Planning application BE/151/11

Application BE/151/11

SHRIPNEY GARDEN CARAVAN PARK, SHRIPNEY LANE, SHRIPNEY
Proposals 01
Nov 2011

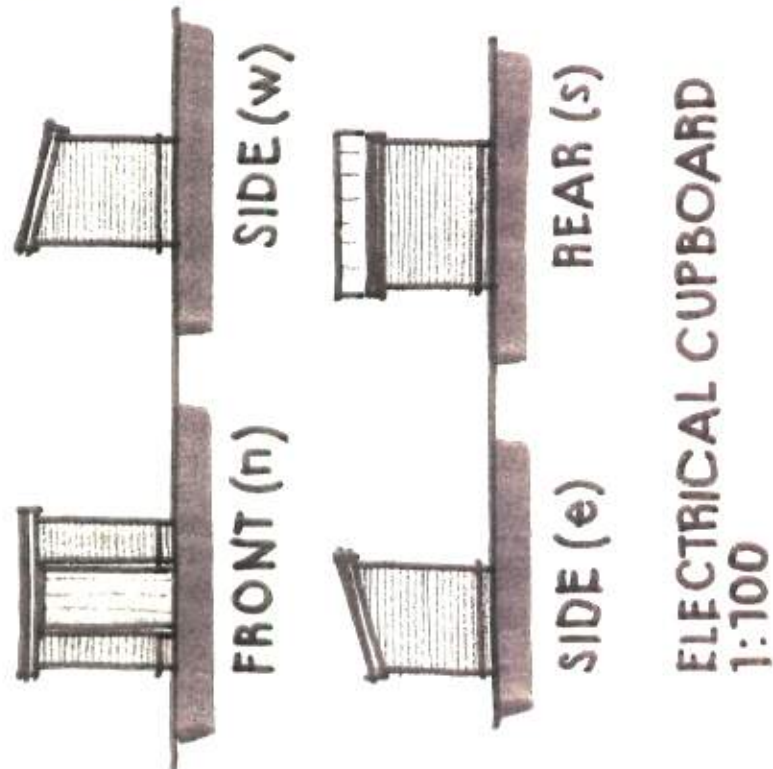
1. The application states that there are no trees or hedges adjacent to the site that might be important as part of the local character. This is untrue. The whole length of the boundary to the south is a conservation area with a range of mixed trees and hedges. The new siting of the caravans encroaches significantly on the conservation area.

3. PDAS section 1.03 is totally untrue. The new application shows the bases to be significantly (approximately 4 metres) closer to the conservation area than the original.

- **Not one** of the caravan pads is in the same position as the original plan
- The eastward boundary has moved 30m not 12m as the applicant has laid a tarmac road some 20m beyond the last caravan
- The access has moved significantly closer to the conservation area
- The site now doesn't appear to include a section in the north of the site – which has been used to move a caravan from the original caravan park
- The car park has changed – although perhaps not significantly
- There is one access road not two
- There is a new brick structure housing electrical intake

- a) some of the mobile homes to the south side are half the distance between the neighbouring properties than they were originally designed to be. The properties are within the conservation area. Planning guidance specifically states that any development near a conservation area should be sensitive to the area. Slapping seven mobile homes within 4m is NOT sensitive.

- b) the extension to the eastwards is in an extremely exposed position (the committee will note that trees T3 and T4 previously gave some limited form of screening – and now there is none)

7. Regarding design (4.01 to 4.03). Firstly the electrical intake is not appropriate as it is adjacent to the conservation area. Regarding 4.03 – the wall was not unstable. It was, as is shown by the last remaining bit in the south west corner of the site, as solid as a rock. It was extremely well constructed. If the wall was unstable then a) why did the applicant originally propose keeping it? Did it suddenly become unstable in the few weeks after approval was granted? Please could the development committee see the report on its instability which presumably was lodged with the planning authority at the time and the request to amend the development at the time?

1. Places caravans significantly closer to the residential development and conservation area
2. Extends the site and places additional caravans in an area that is not screened from its neighbours

3. Places an entrance closer to residential properties where cars will stop with their engines on at all times of the night to open and close gates
4. Places an electricity station inappropriately immediately next to a residence

5. Includes an extra 30m of tarmac road over agricultural land, for which there is no reason or need. The land is protected under PPG7
6. Has been planted with Leylandii which cannot in anyway be seen to be protecting the sensitive location adjacent to a conservation area. The original application was agreed with a mixed hedgerow with traditional native species.
